Libbytown Neighborhood Association
c/o 11 Stevens Ave
Portland, ME 04102

June 30, 2015

Re.: Future Jewish Community Center
1342 Congress Street
Portland, ME

LANDSCAPE PLAN

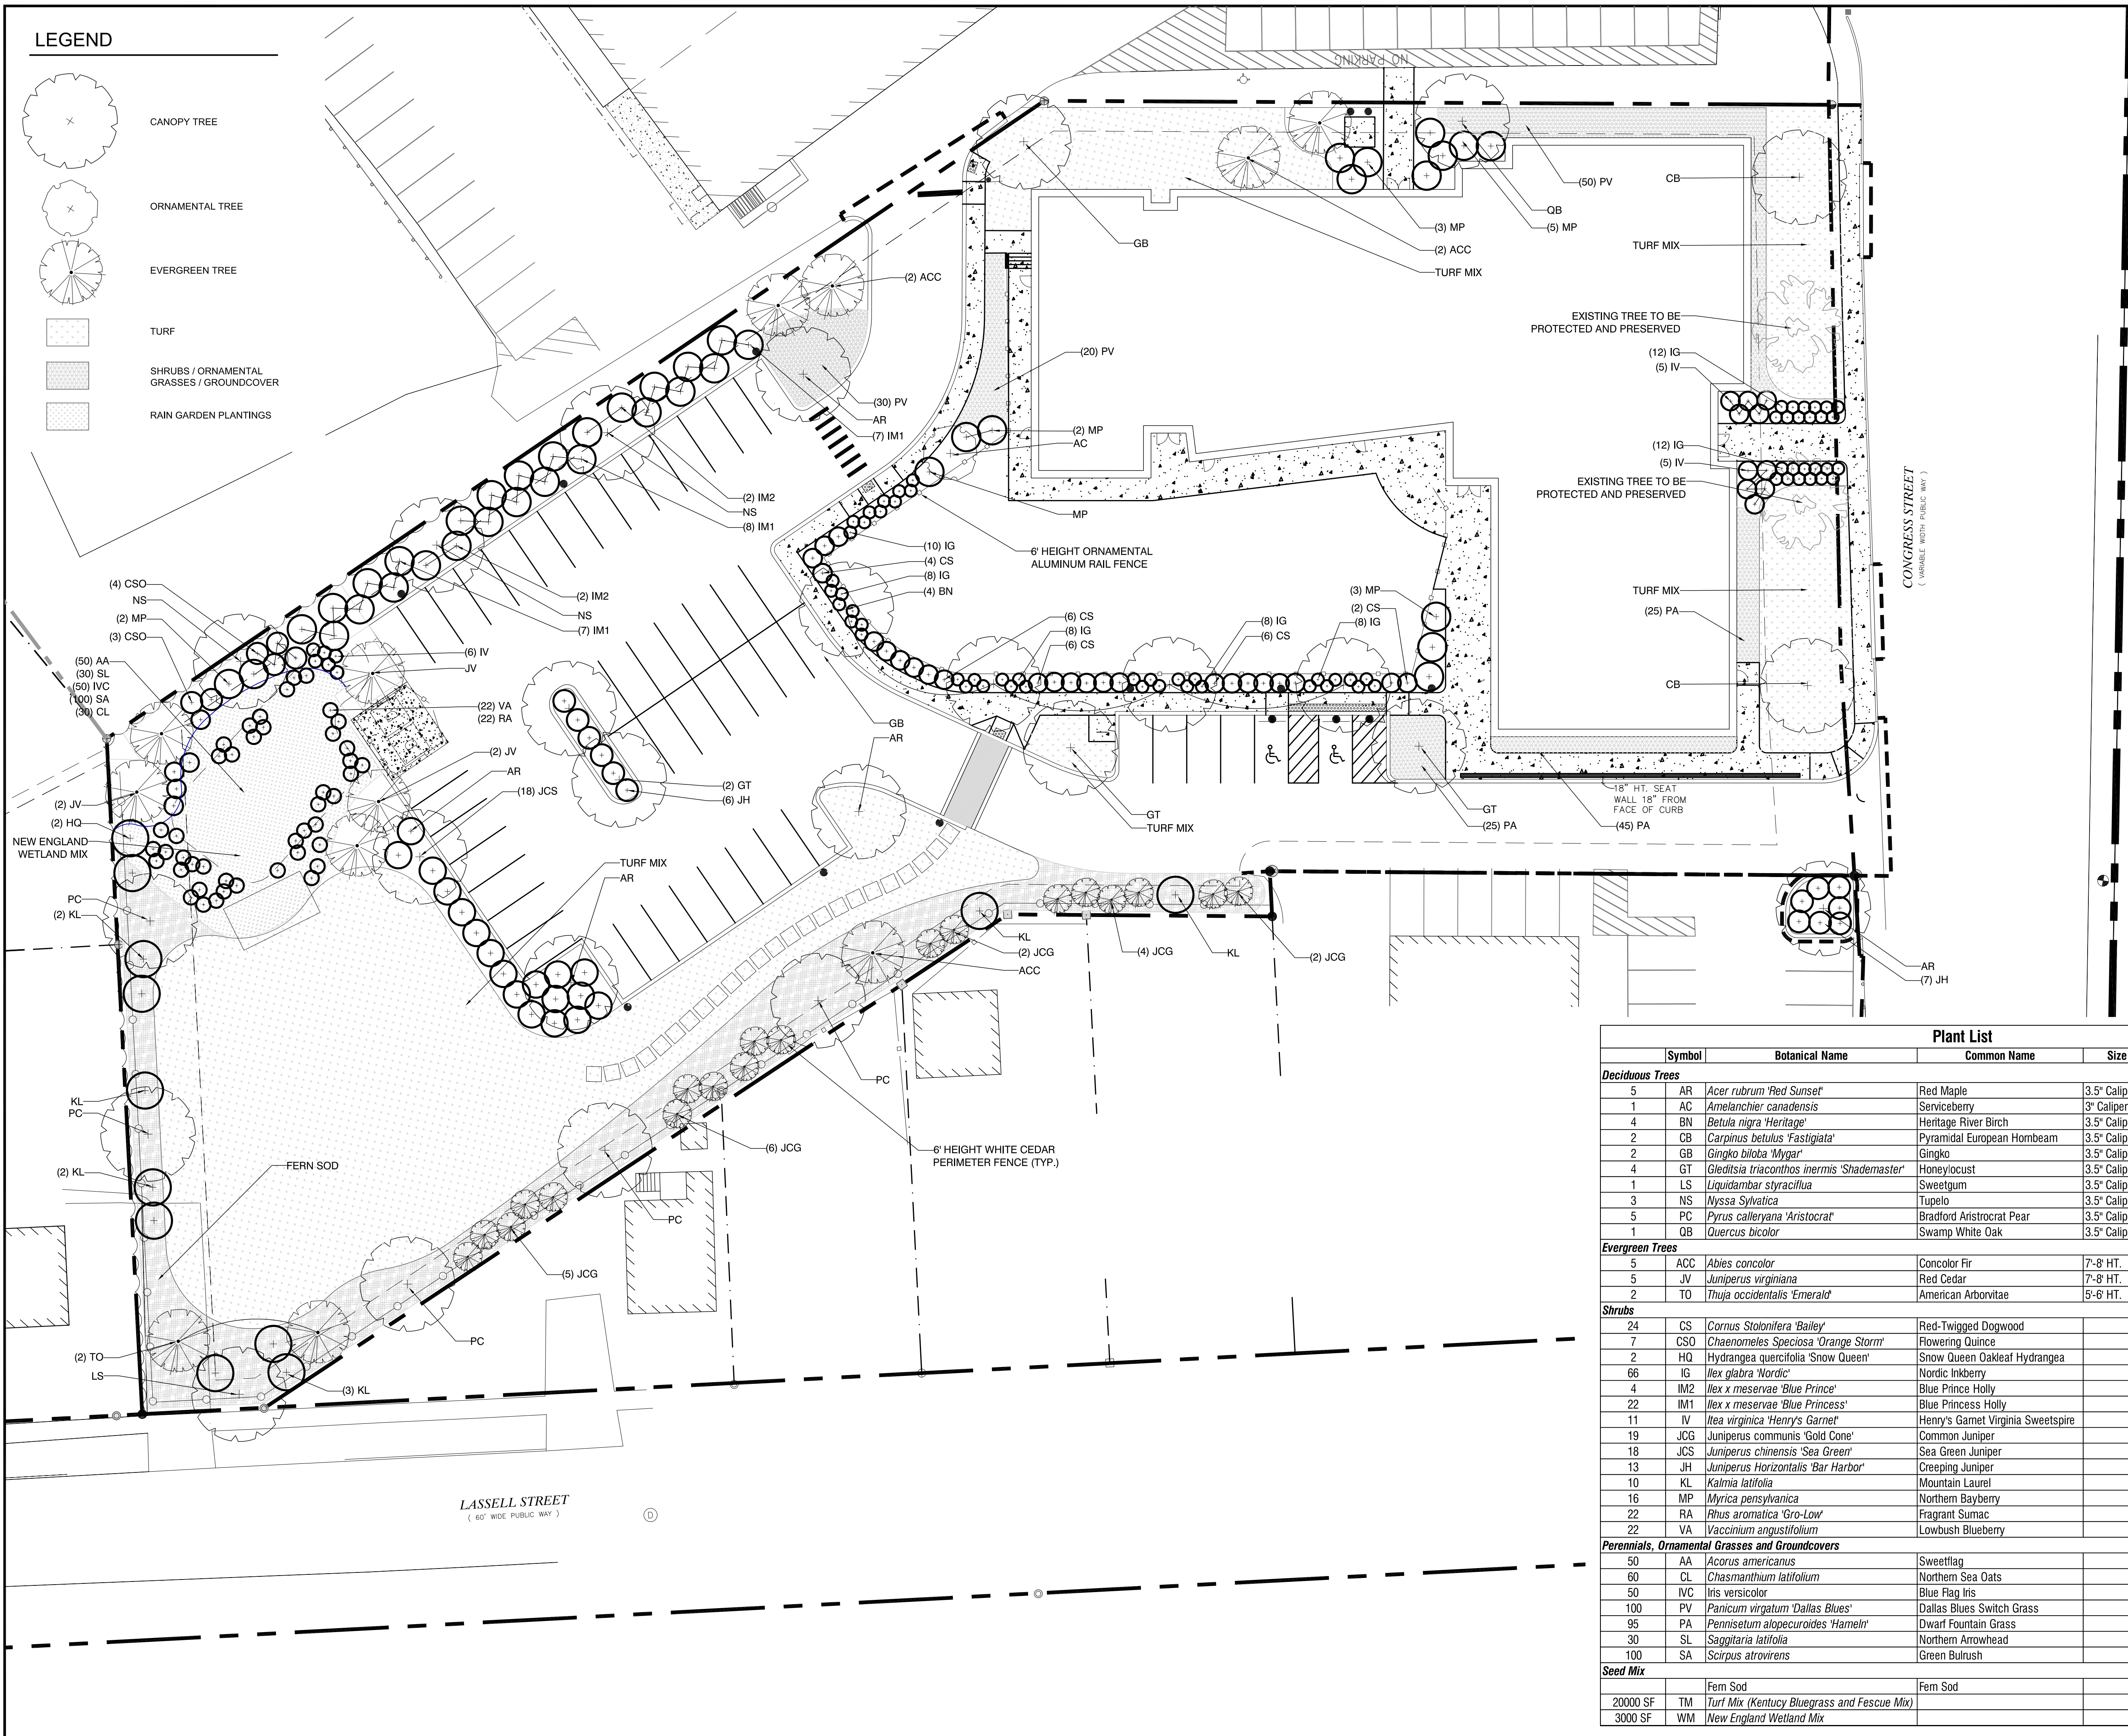
The LNA has been working hard to establish a community garden in the area, and are indeed excited to see that you are including some edible plants in your landscape design (lowbush blueberries). We would encourage you to replace other plantings with even more edibles as well. For example, replacing the dogwood tree with an apple tree or cherry tree. Additionally, work nationwide has focused on increasing children's access to vegetable gardening and we would encourage building this into the plan for the daycare facility as well.

A20.2

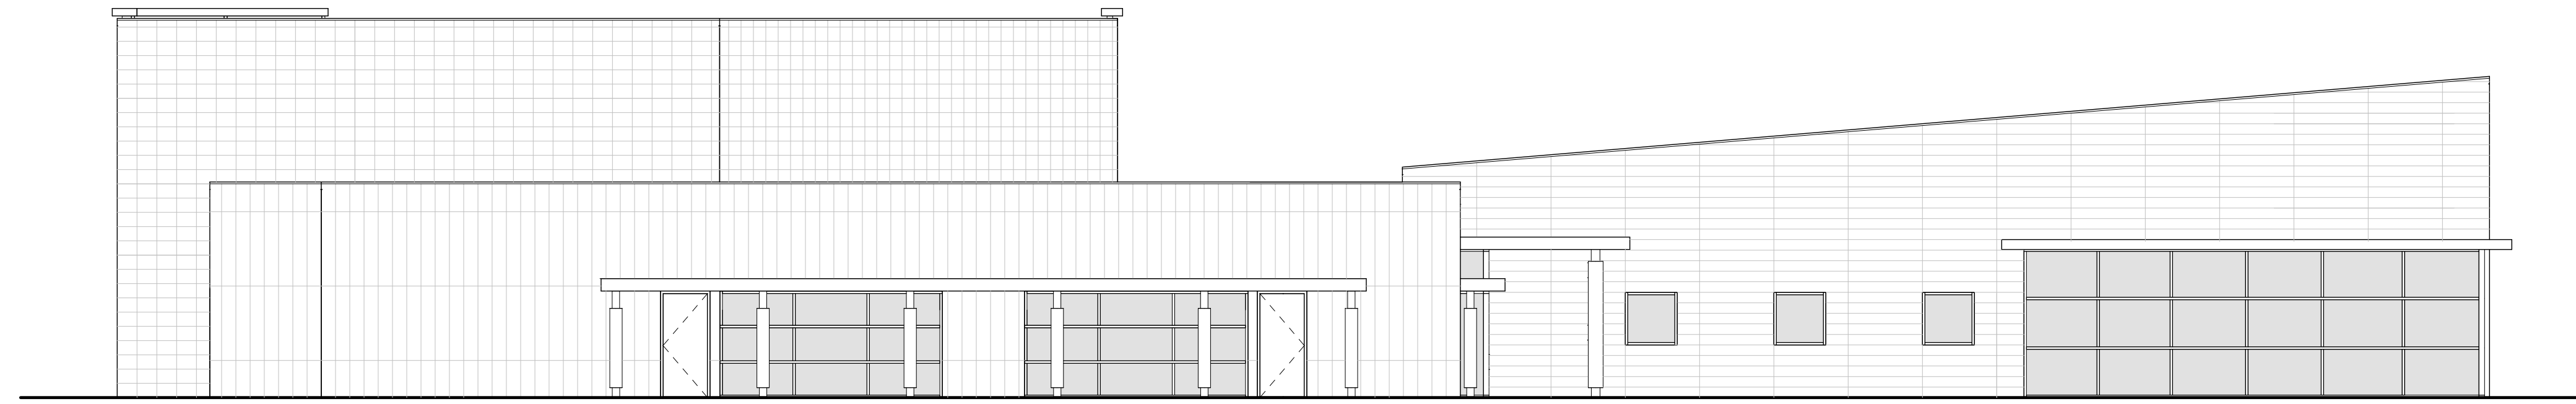
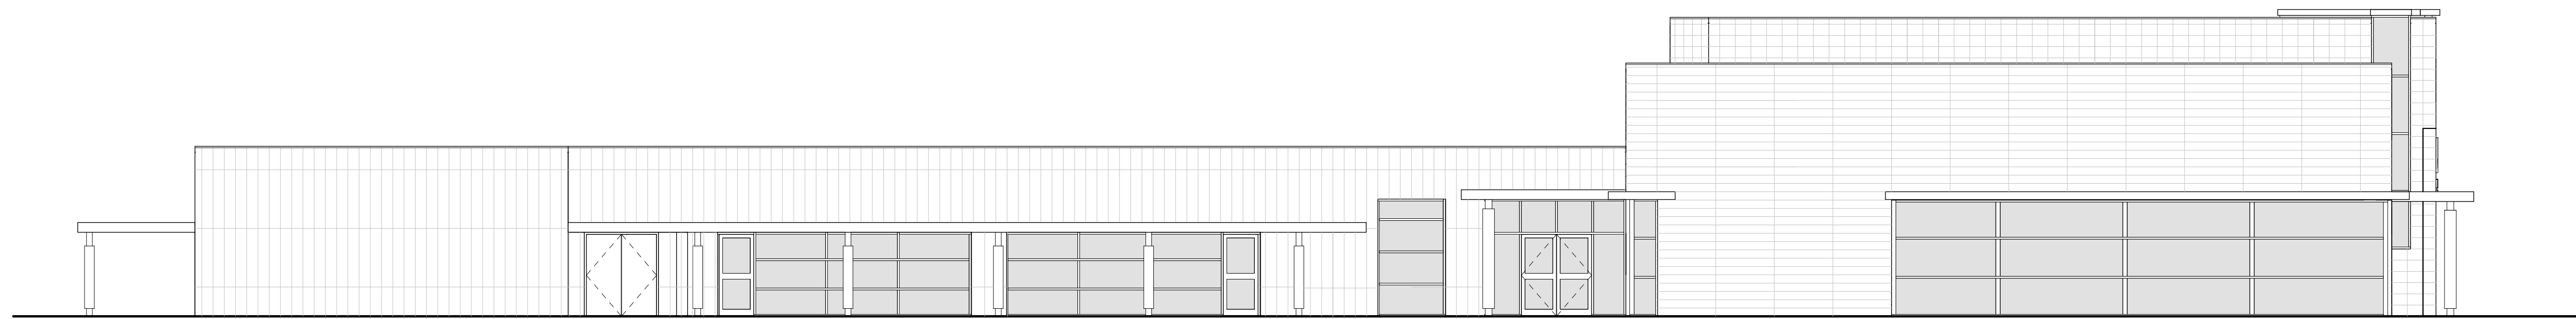
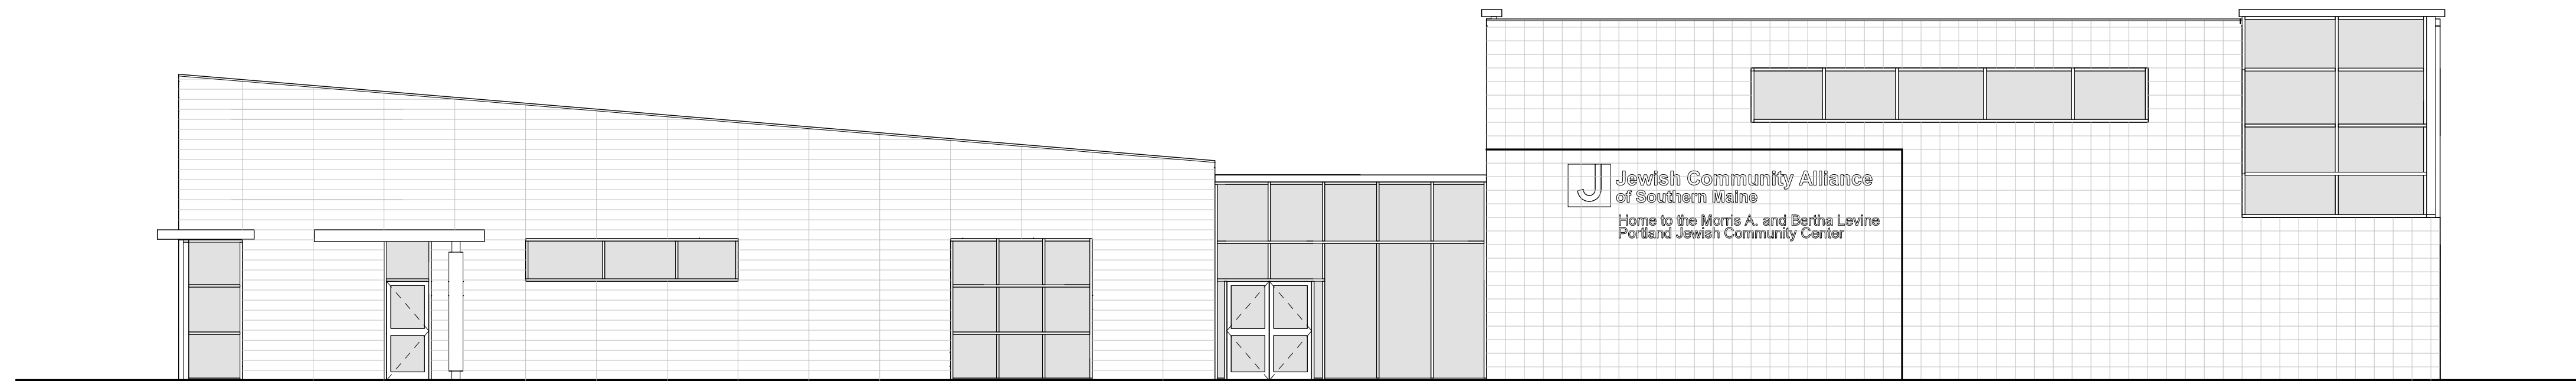
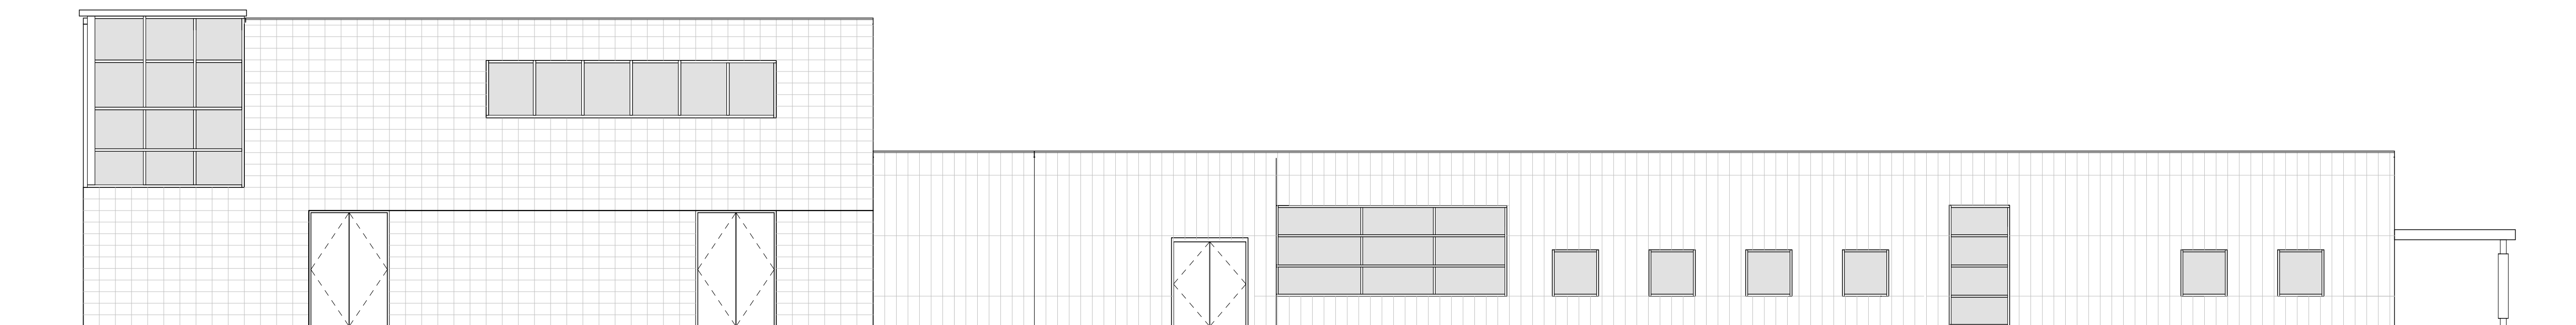
One of the concerns we do have is that the front facade at the gymnasium, as presently drawn, is a large, blank box (Harriman Associates, Drawing A201, undated). We see on the revised exterior elevations dated June 24, 2015 that some additional embellishment has been added, but we hope for additional enhancement as well. We understand these are preliminary drawings and we hope that as the plans develop, some sort of visually-stimulating feature – perhaps a mural, or mosaic, or even large banners – will be integrated to enliven this blank area. We want to keep our streetscape interesting, fun and engaging to those who are walking by at a slower pace than quickly moving autos.
